EL PASO COUNTY CONSTRUCTION STORMWATER SITE INSPECTION REPORT

| Facility Name: Sterling Ranch Filing No.2 | Permittee: SR Land LLC |
| Date of Inspection: 07/27/2022 | Weather Conditions: Partly Cloudy |
| Permit Number: ESQ2137 | Disturbed Acreage: 211.16 acres |

**STERLING RANCH FILING NO.2**  
**POND W5**

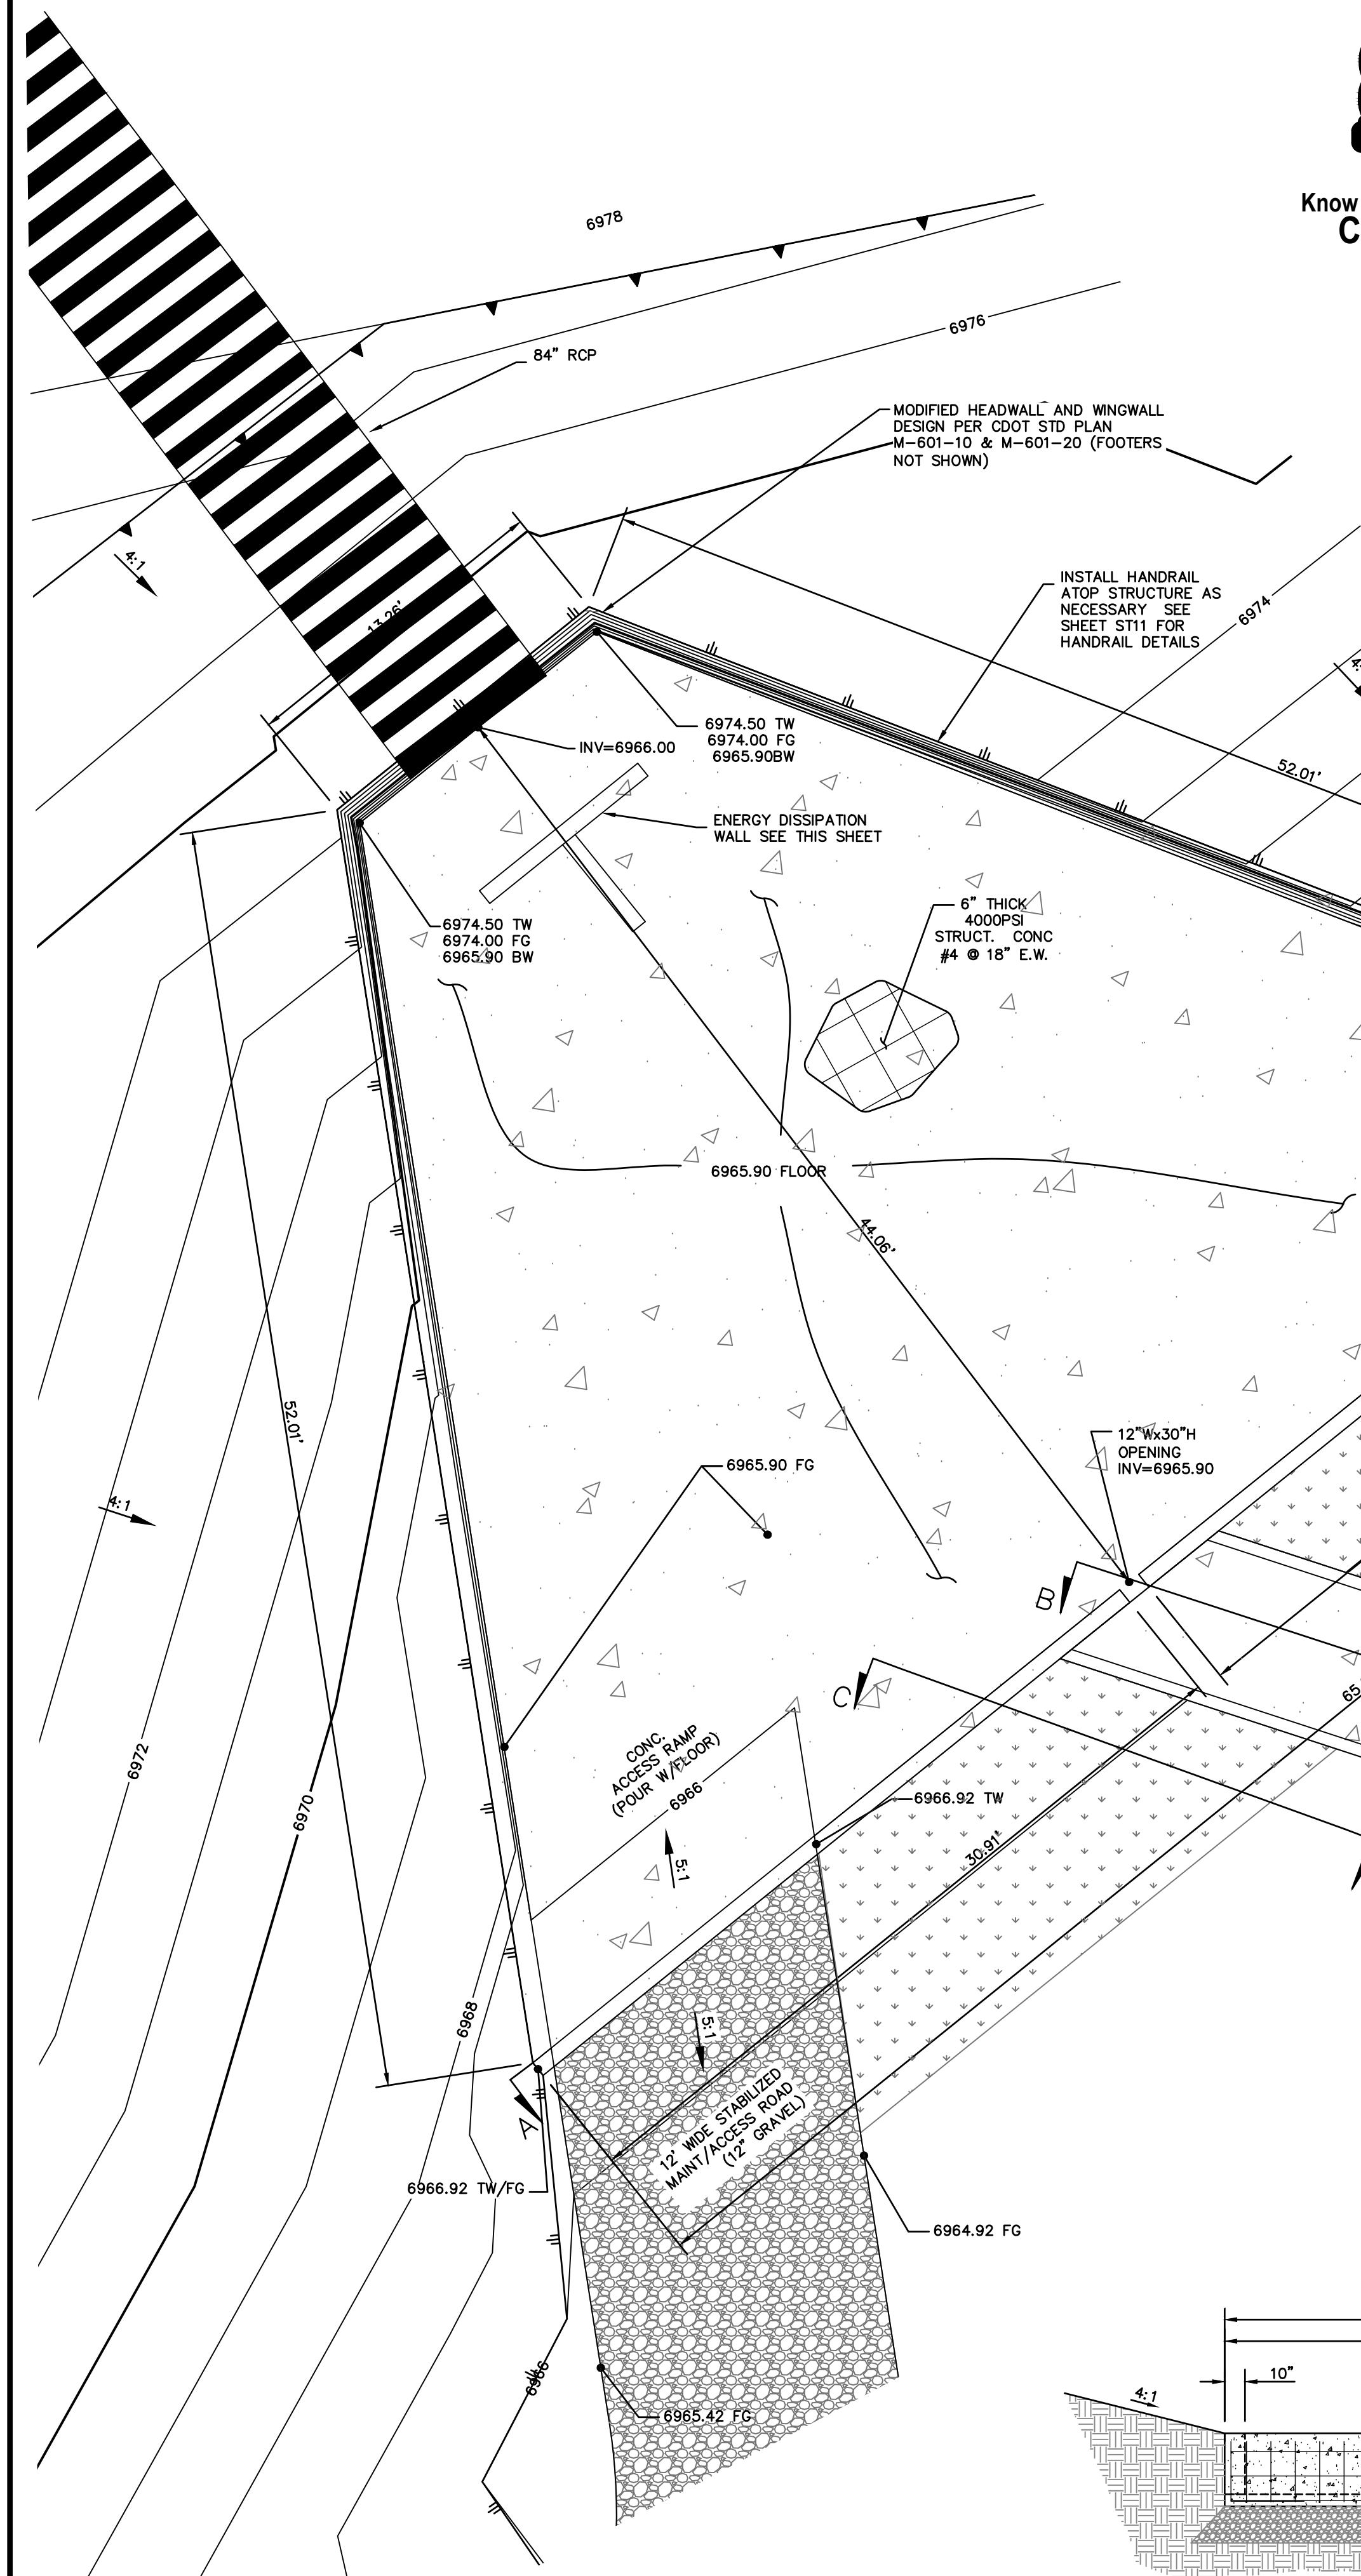
Implement control measures to prevent sediment from entering water quality pond 5 at outlet structure.

Properly dispose of cured concrete and implement CWO near pond 5.

Address gully formation and unprotected stockpile at Box up gradient of WQ pond 5.

Extend ECB stabilization matting to encourage vegetative establishment along embankment at WQ pond 5.

Ensure straw wattle control measure is staked down as per detail at WQ pond 5.

**FULL SPECTRUM DETENTION POND W-4**  
**SITE PLAN**  
SCALE 1"=30'

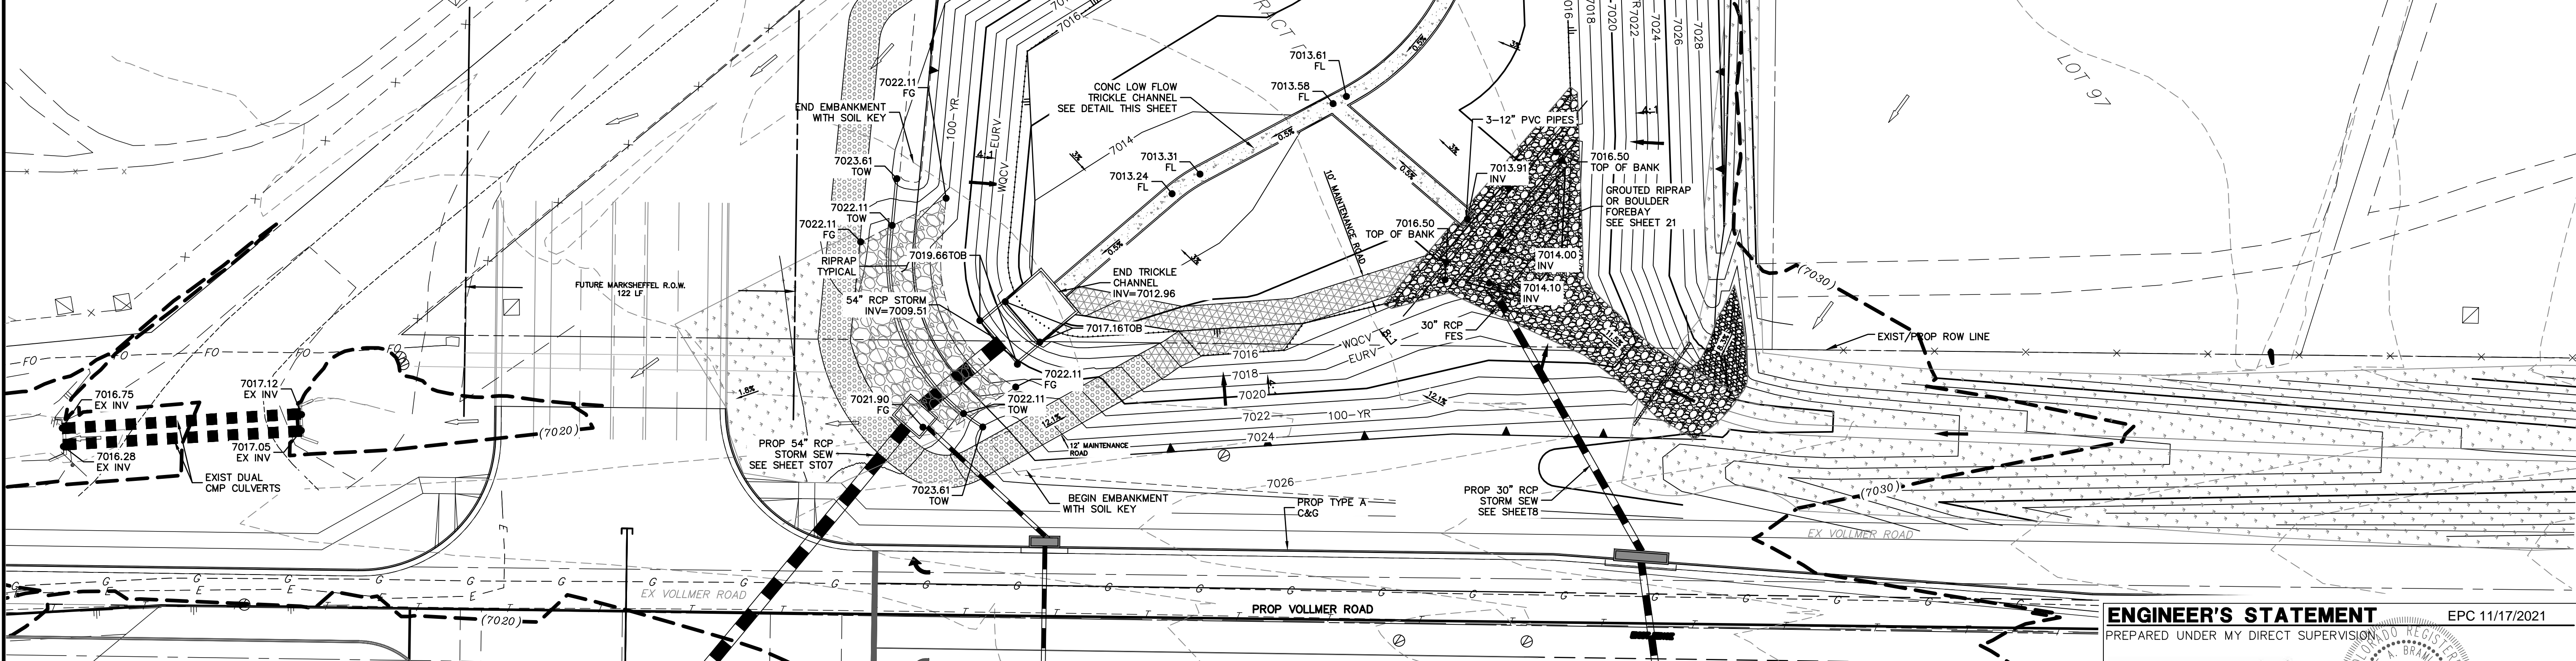
| WQ pond 4 and Northeast rock check dams | Failure to implement control measure | Failure to implement control measure as per plans. |

Install WQ pond 4 and associated structures as per approved plans.

Implement Northeast rock check dams to pond 4 as per approved plans.
